PREFERRED PROJECT REPORT

**12-38 AND 40 BONAR STREET AND
5 LOFTUS STREET, ARNCLIFFE**

DECEMBER 2009

September 21 - Shadow Diagram - 9 am

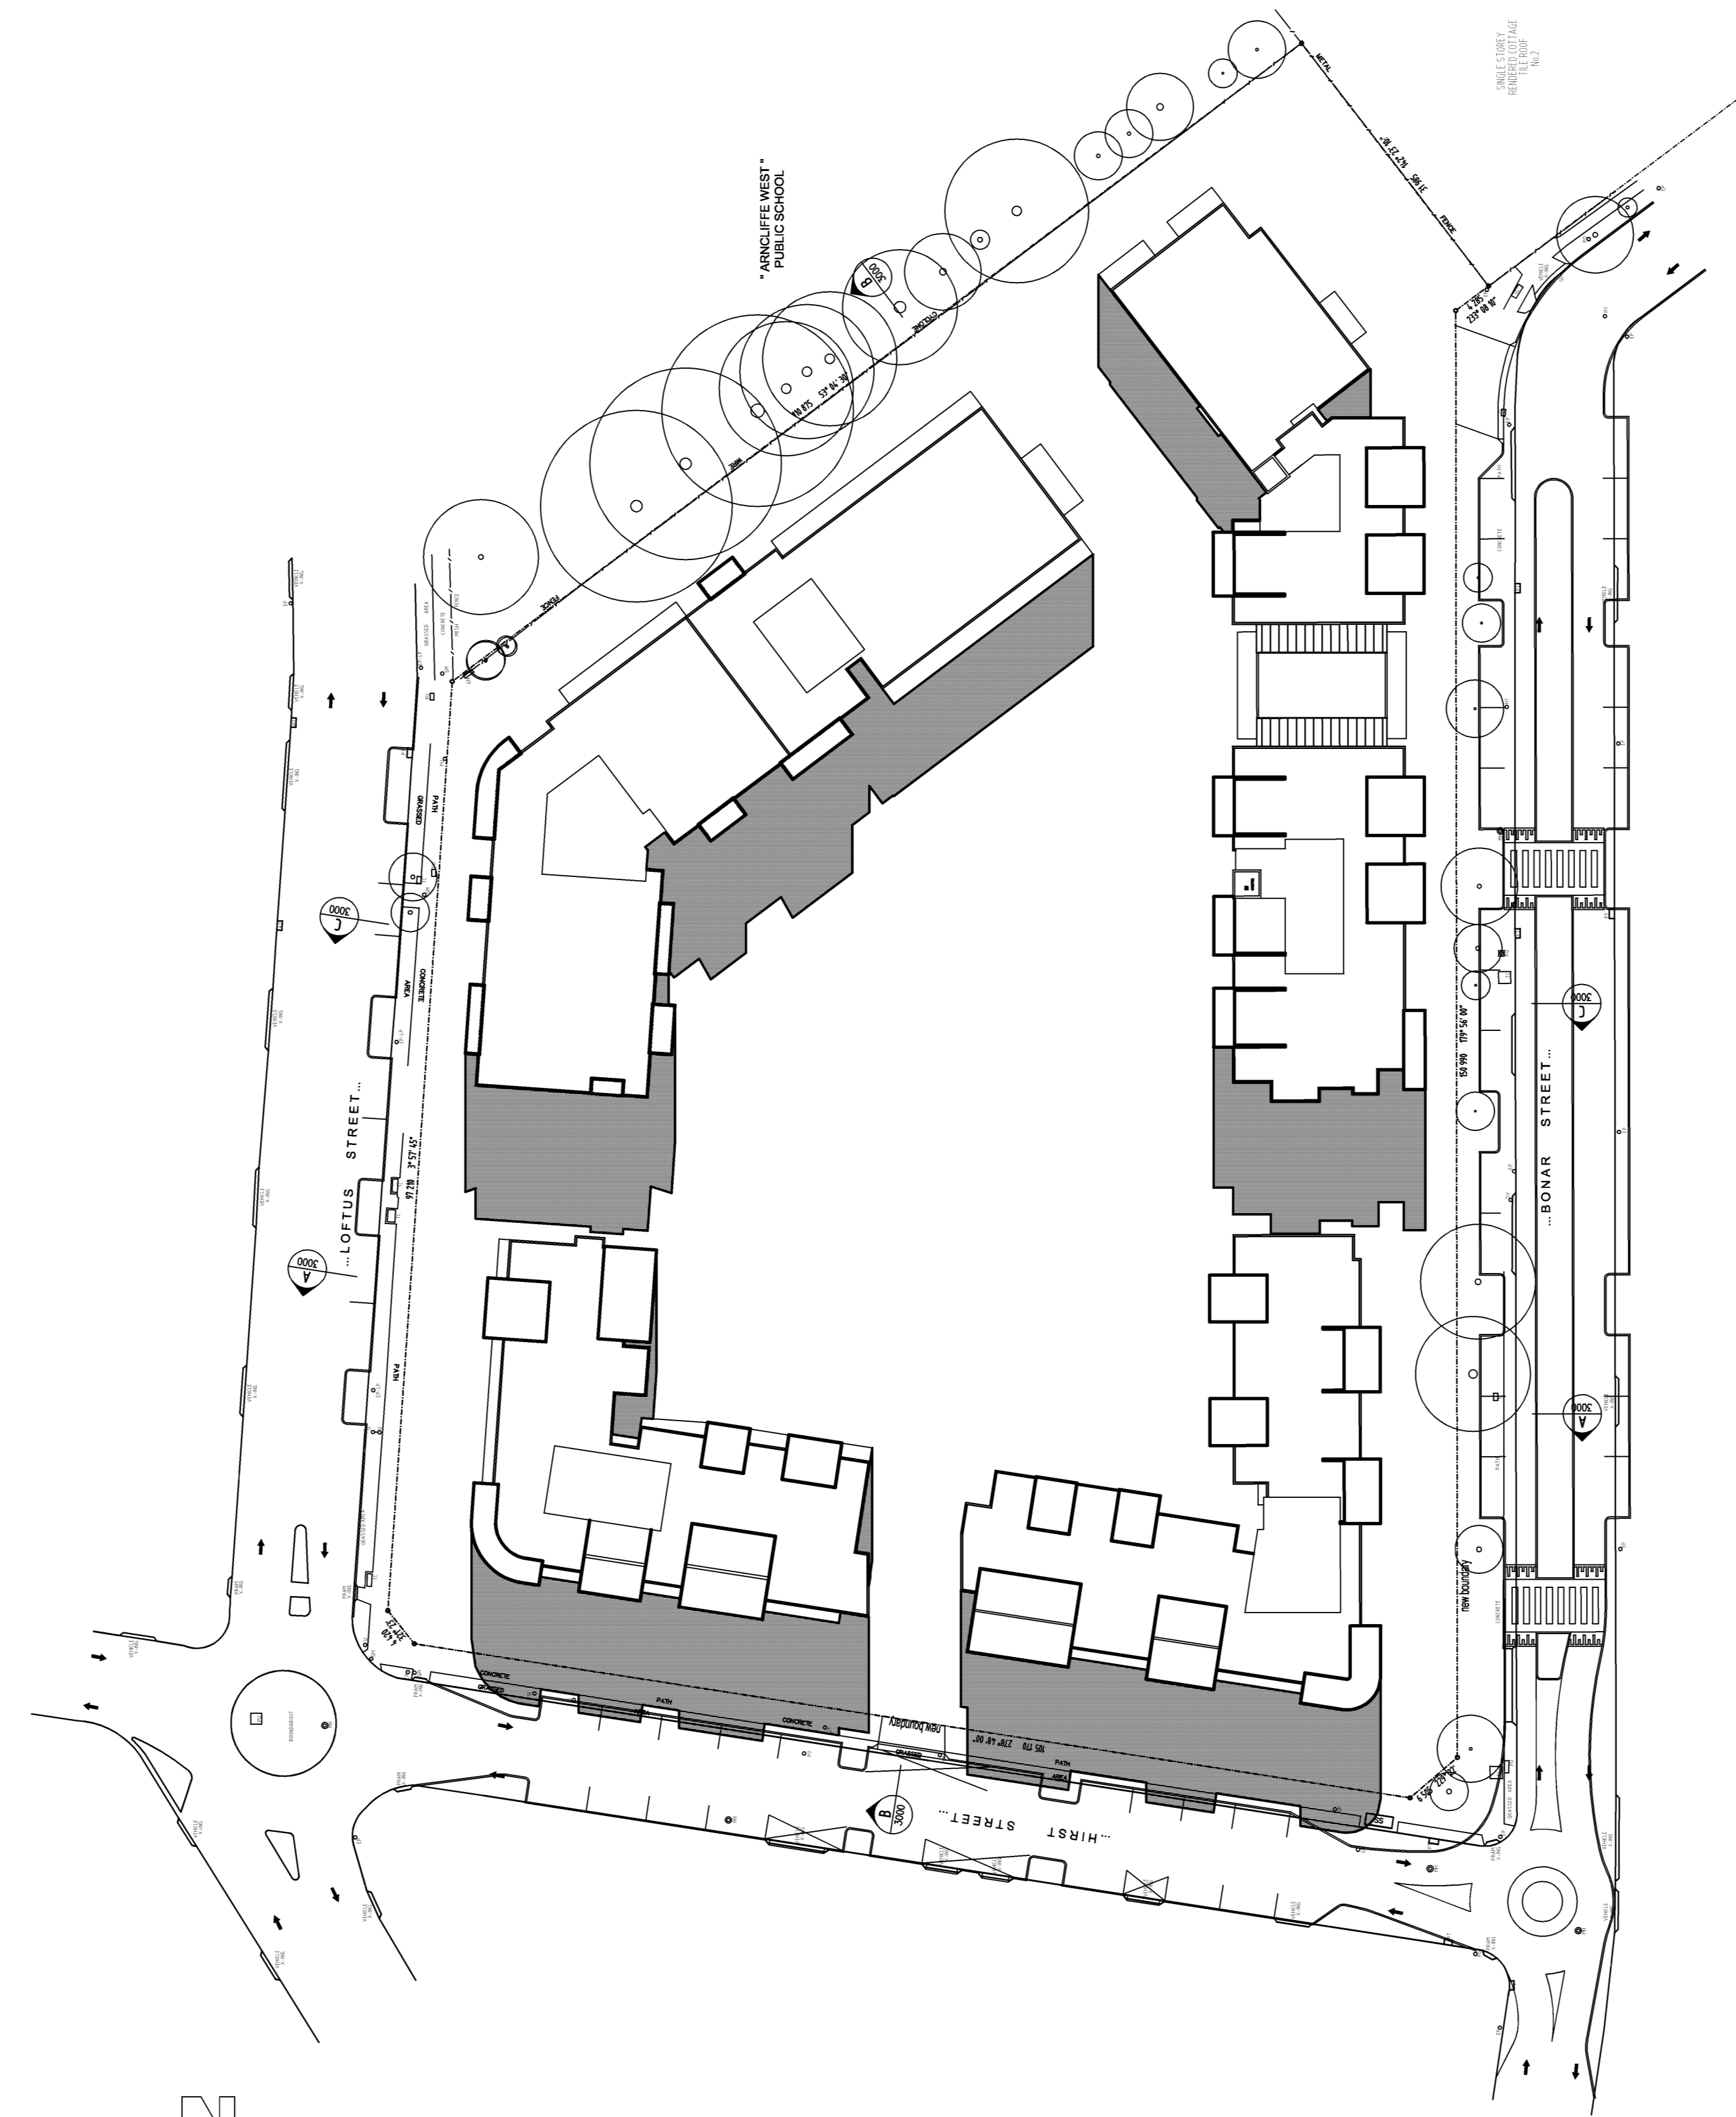
Clause 53A(2D) of the Rockdale Local Environmental Plan 2000 states that the maximum height may be exceeded by 3 metres *“but only if the consent authority is satisfied that any such variation from the maximum building height specified for the land in that diagram will not have a material adverse effect on the amenity of the occupants of nearby land.”*

Accompanying this report is additional overshadowing diagrams that show the extent and location of additional shadows cast by the additional height to Buildings A and D.

During December 21, the additional shadow cast is only evident at 9am and 3pm and affects only a small part of Loftus Street and Bonar Street, respectively, and a small part of the internal courtyard of the proposed development.

At June 21, the additional shadow cast is also evident either side of midday. The additional shadow at 9am will be cast towards the future Bonar Street Precinct development site on the western side of Loftus Street; and the additional shadow cast at 3pm will be cast over the future Bonar Street Precinct development site on the eastern side of Bonar Street. No existing residential properties will be affected by the additional overshadowing.

At Equinox (March and September 21), the additional shadow cast will essentially be the median of the summer and mid-winter shadowing impacts. No existing residential properties will be affected by the additional overshadowing.
